Application Ref:	3/2025/0141			 Ribble Valley Borough Council <small>www.ribblevalley.gov.uk</small>
Date Inspected:	31/07/2025	Site Notice:	28/08/2025	
Officer:	MC			
DELEGATED ITEM FILE REPORT:				REFUSAL

Development Description:	Regularisation of erection of three commercial buildings (10 commercial units Use Class B2, B8 and sui generis) and associated works.
Site Address/Location:	Bolton Fold Farm, Alston Lane, Longridge, PR3 3BN

**Drawing Title**  
 PROPOSED SITE PLAN

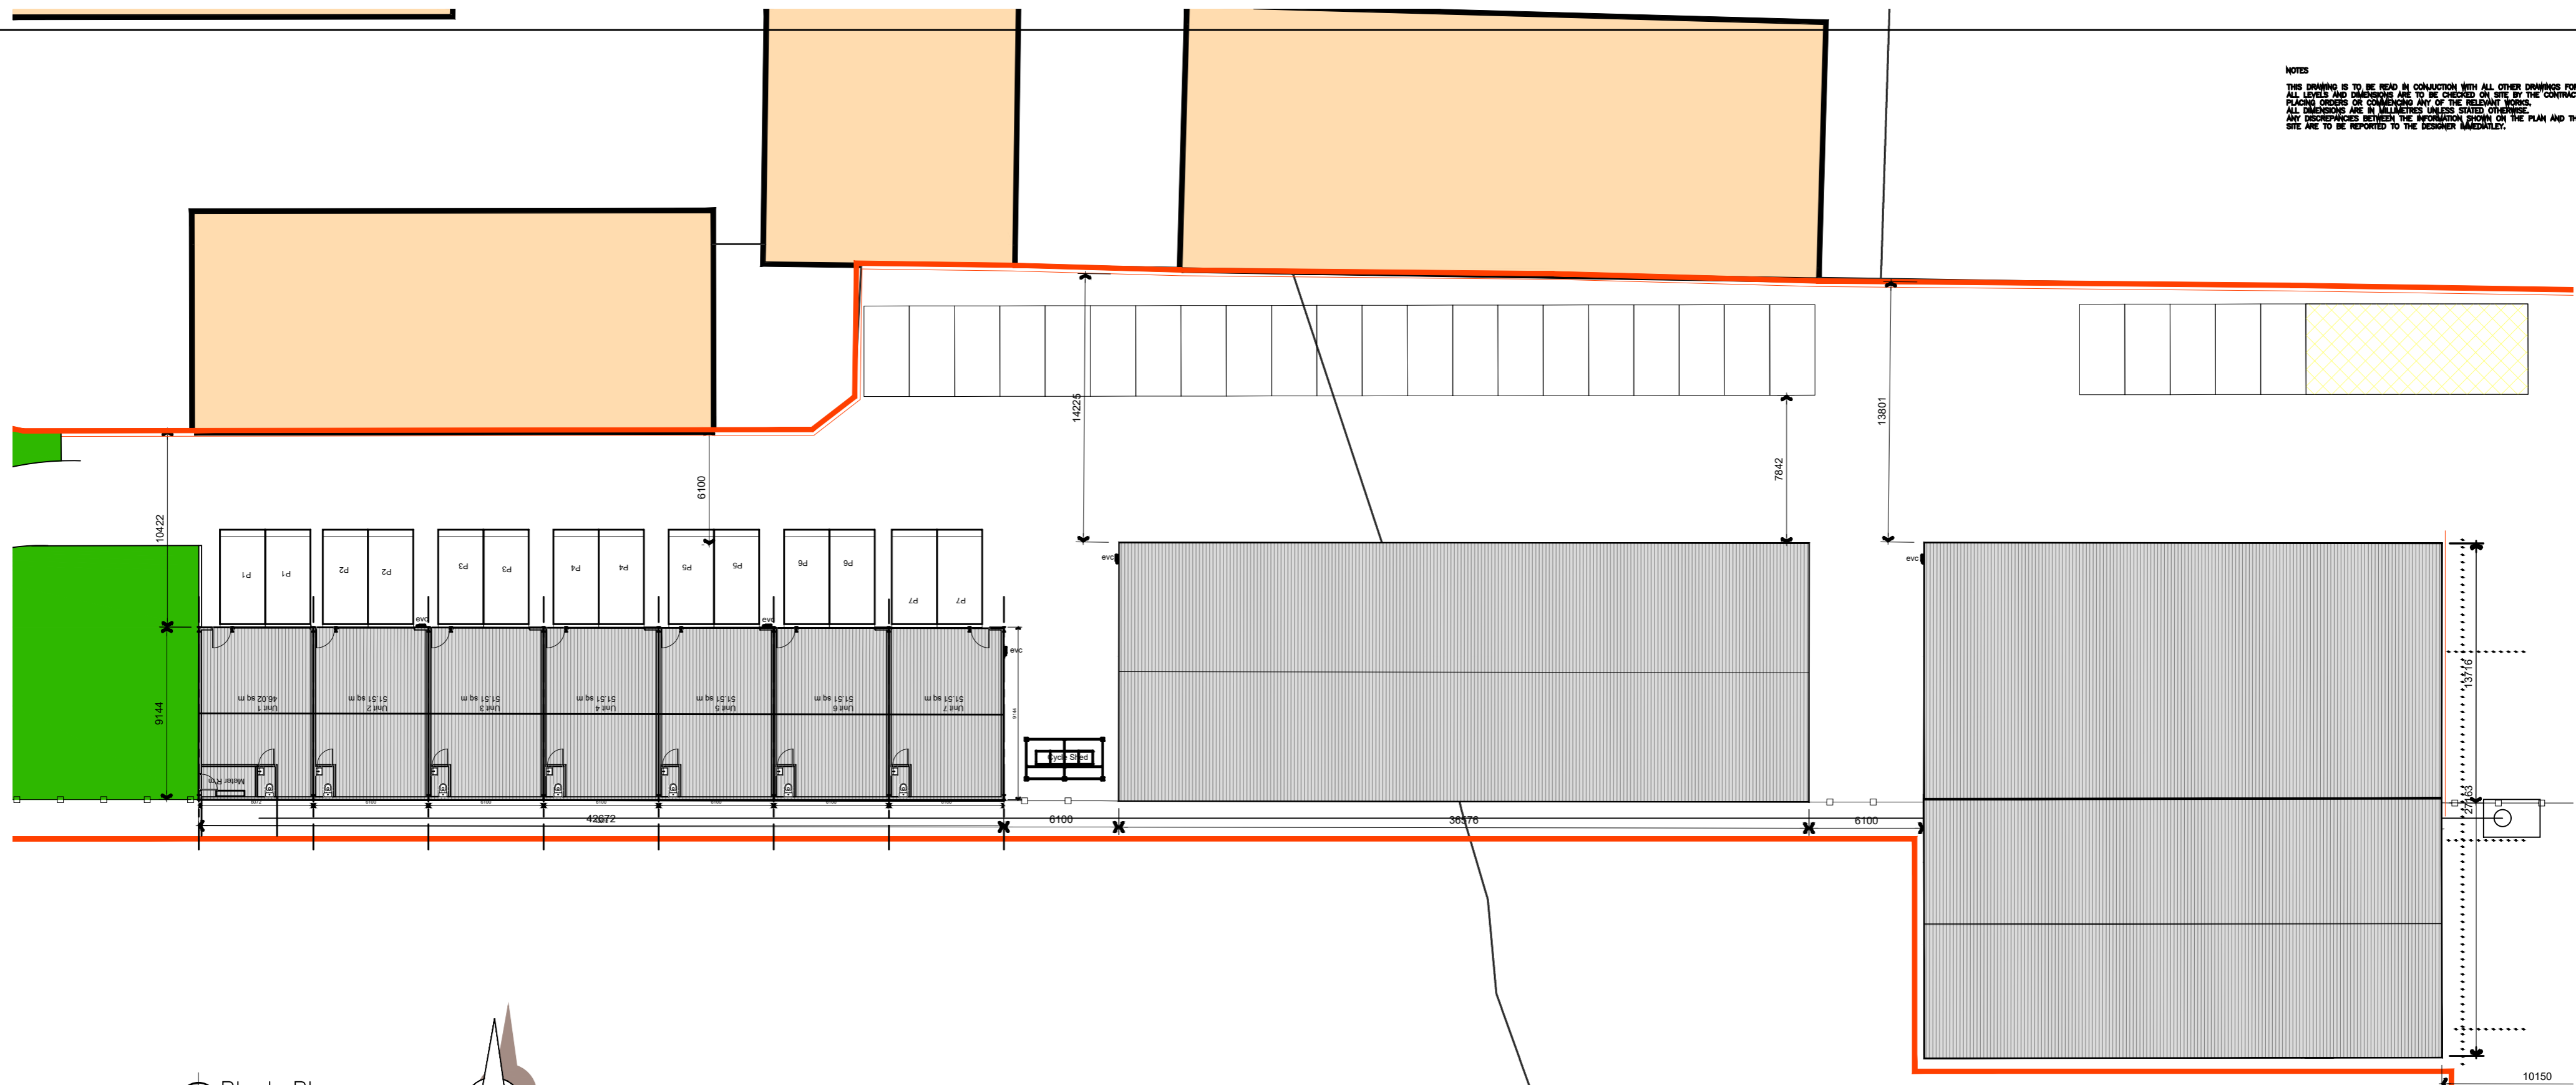
The agent has provided further details on the use of each commercial unit within the site. Units 1-7 measure a total of 387m², requiring a ratio of 1 parking space per 45m² which is a total of 9 spaces. Units 8-9 measure a total of 505m², requiring a ratio of 1 parking space per 45m², which is a total of 12 spaces. Resulting in a total of 21 spaces. They note that Unit 10 measures 745m², requiring a ratio of 1 parking space per 200m², which is a total of 4 spaces. The LHA has reviewed the updated site plan, drawing number 0 7 D, which shows a total of 26 parking spaces situated along the north edge of the site. As such, they consider that there is an appropriate and sufficient parking for the site.

The LHA note that a dedicated cycle store has been provided within the site next to unit 7. Additionally, charging points for electric vehicles are included in the development to promote sustainable modes of transport.

As such, the LHA raise no objection the development subject to conditions relating to the off-site highway works, the provision and retention of car parking and turning areas, the provision of EV charging points and the provision of cycle storage.

Job/Scheme Number	Drawing Number		
0616/93	Drawing No 15 A		
Scale	Date	Drawn	Checked
1 / 100	May 21	a.t.l-h.

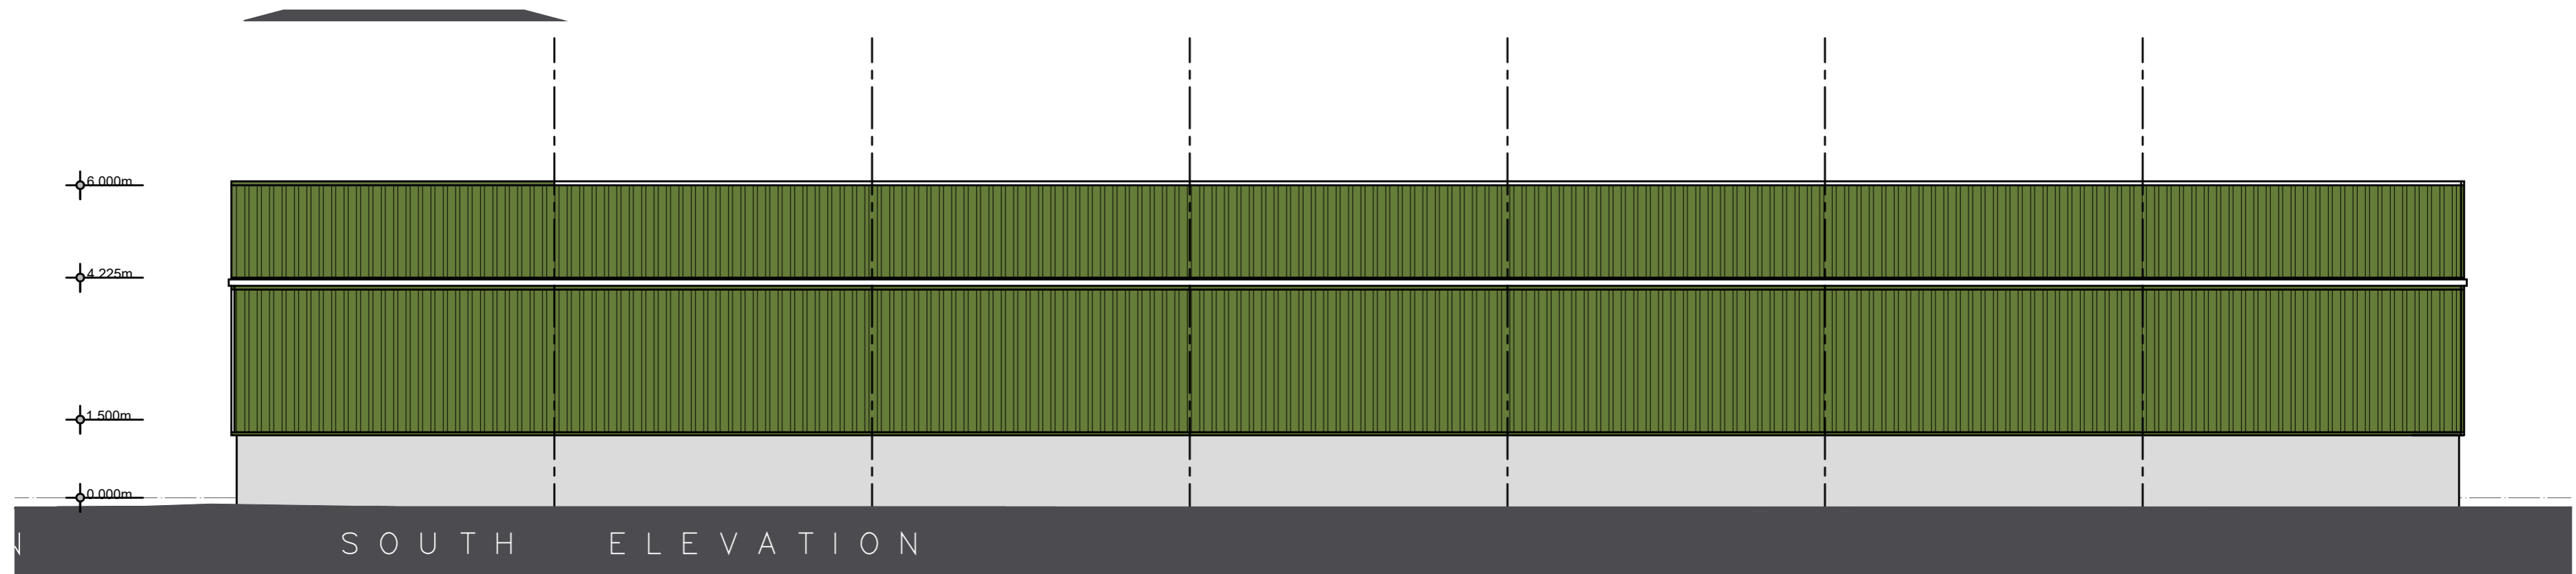
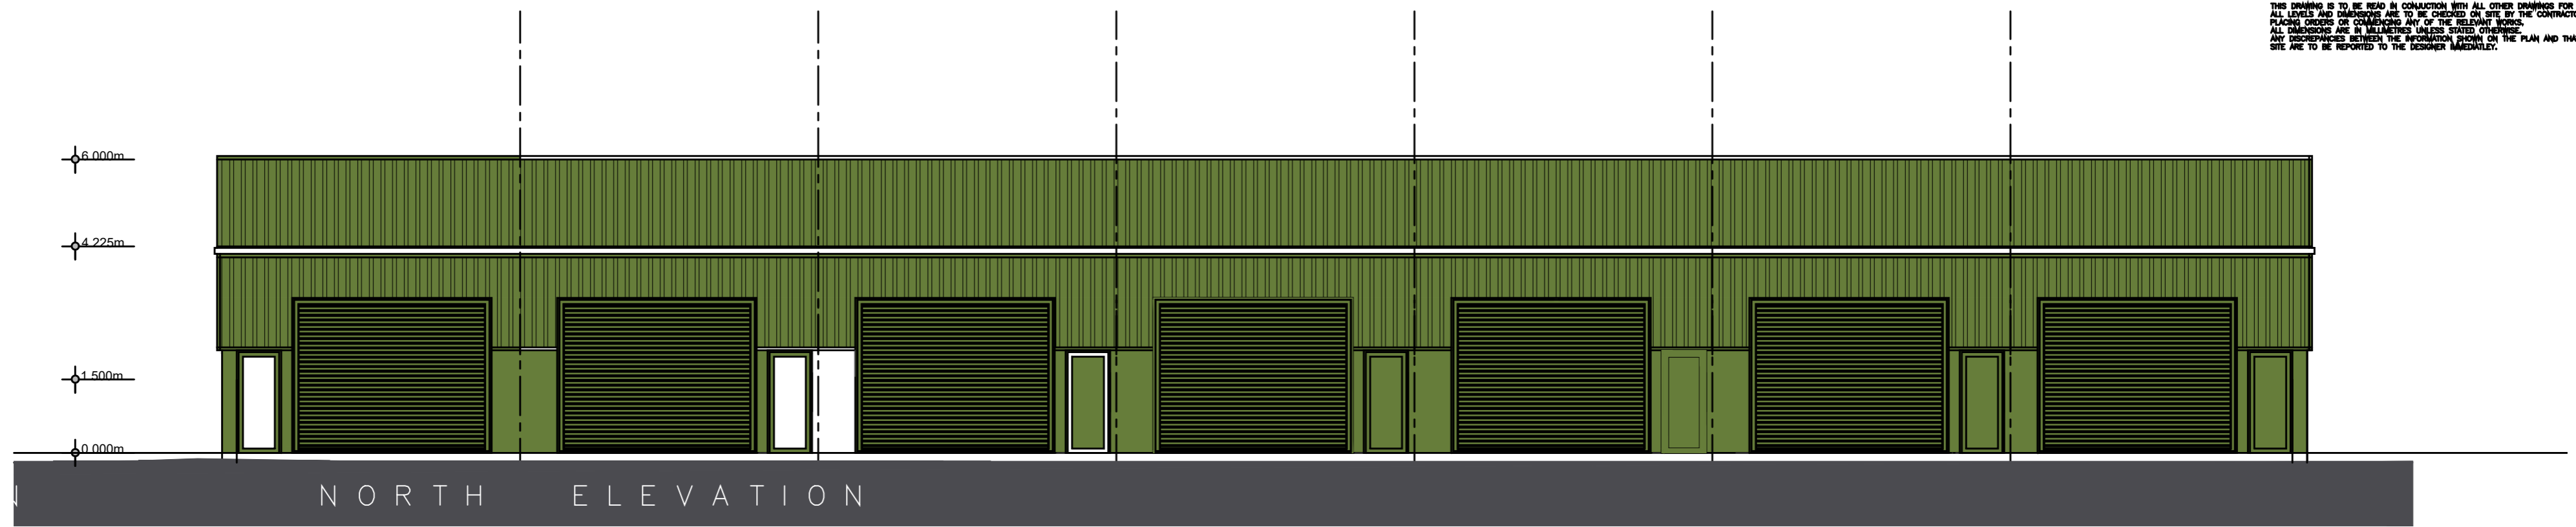
Each building has a dual pitched roof with a pedestrian door and a roller shutter door to the front elevation. The external materials of construction include concrete to the lower wall levels and green corrugated sheet metal cladding to the upper walls and roof. The access road and parking areas is constructed of concrete.

- Building 1: 42.6m in length, 9.1m in depth and 6m in height
- Building 2: 36.5m in length, 13.7m in depth and 7m in height
- Building 3: 27.4m in length, 13.6m in depth and 7m in height

The buildings are substantial in size, occupying a total floorspace of approximately 1568sqm, with an industrial appearance including roller shutter doors. The buildings are sited adjacent to the existing farm buildings which are mainly timber clad. Whilst the buildings are mostly screened from road users by the existing hedgerow which runs adjacent to Alston Lane, the hedge cannot be solely relied upon for adequate screening as in the winter months, the buildings are more visible within the landscape.

The industrial units which have been constructed appear incongruous with, and unsympathetic to, the farmstead by reason of their size, footprint and external materials and are not considered to constitute good design that responds positively to the local character and distinctiveness of the surroundings, contrary to Policies DMG1 and DMG2 of the Ribble Valley Core Strategy and Policy LNDP3 of the adopted Longridge Neighbourhood Plan.
